From: Planning and Safeguarding <planning@wsairport.com.au>
Sent: Wednesday, 4 June 2025 10:25 AM
To: Jess Fountain; Natasha Williams
Cc: Deana Burn; Kirk Osborne; Planning and Safeguarding
Subject: [SEC=OFFICIAL] RE: Notice of Exhibition – Elizabeth Enterprise Precinct – Stage 1 (SSD-19618251)

Thank you for the opportunity to comment on the State Significant Development Application (SSD-19618251) for a concept masterplan including seven warehouse buildings and an internal road network located at 1669-1732 and 1669A Elizabeth Drive, Badgerys Creek (also known as the Elizabeth Enterprise Precinct). This application seeks approval for the Stage 1 development works including the construction and fit-out of two warehouse buildings and associated site works. We understand that the proposal comprises:

Figure 10: Interim Intersection Design (approved by Penrith City Council, DA24/0775)

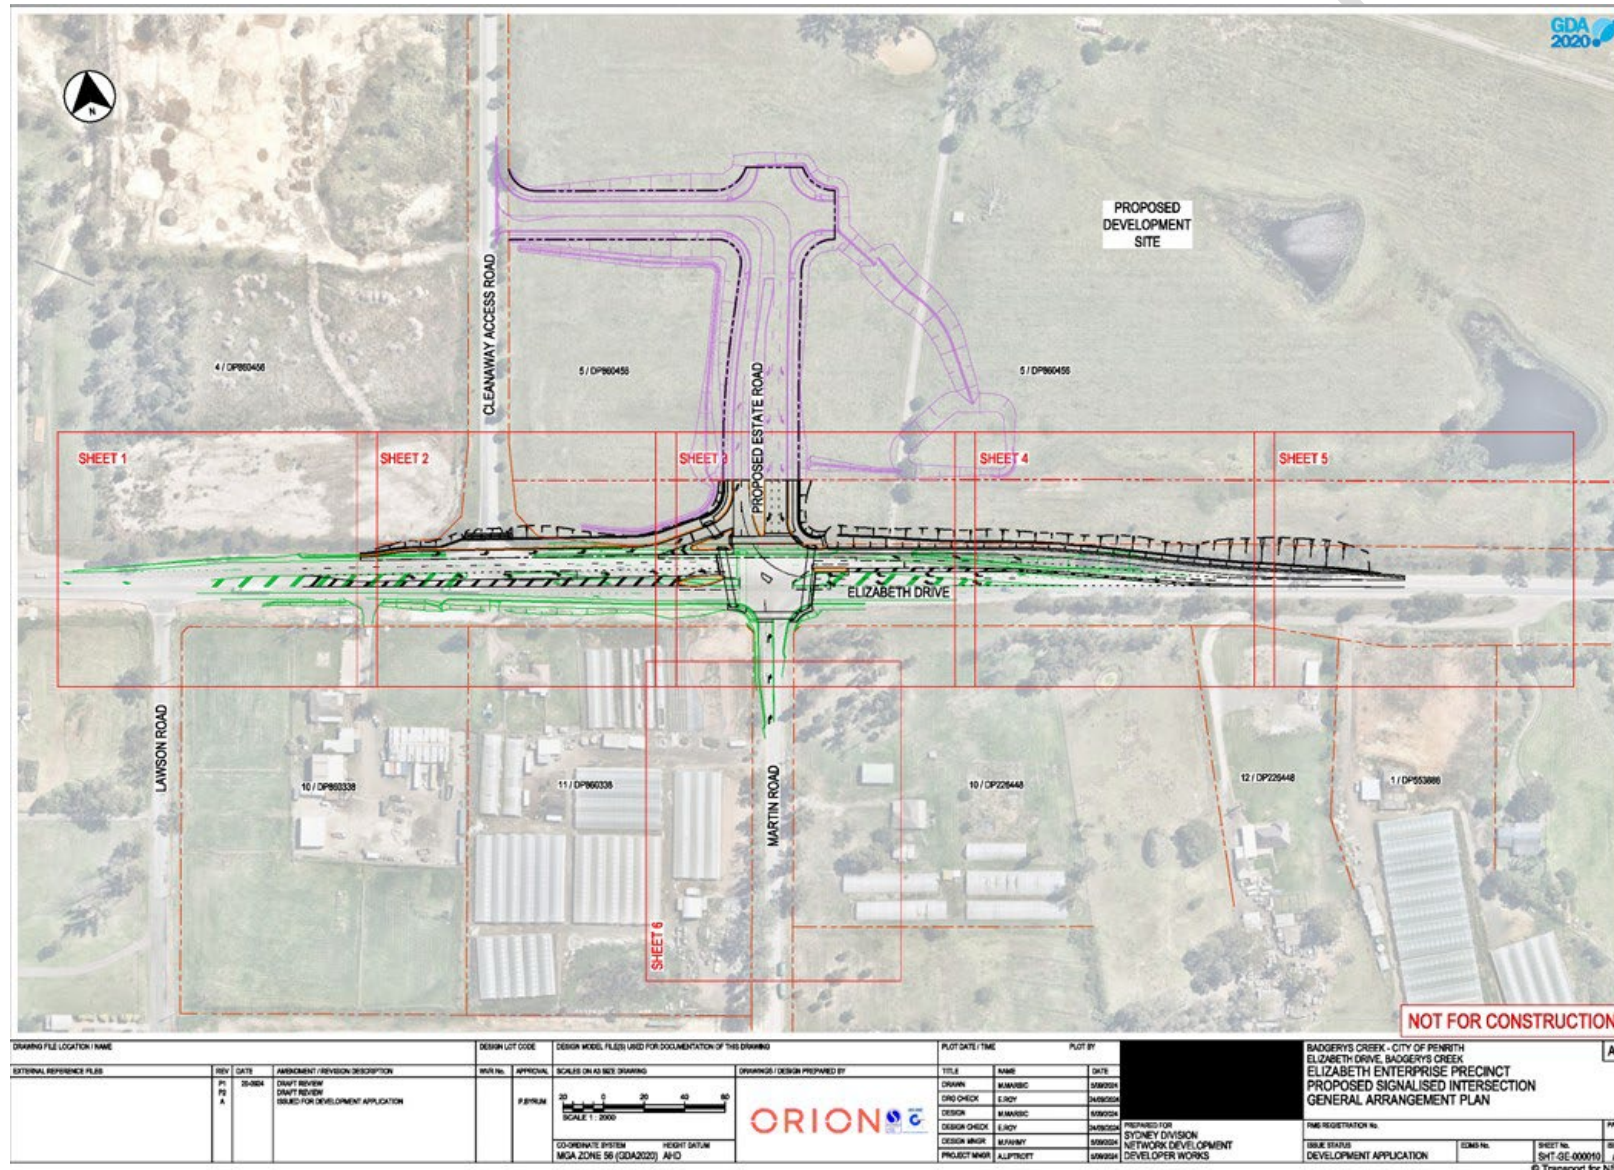
Traffic	<p>A Preliminary Construction Traffic Management Plan has been included in the submitted Transport Assessment prepared by ASON. It is noted that the preliminary plan relies on a roundabout at the Elizabeth Drive and Badgerys Creek intersection. This roundabout has since been replaced with a signalised intersection. This is to be considered in the detailed Construction Traffic Management Plan.</p>
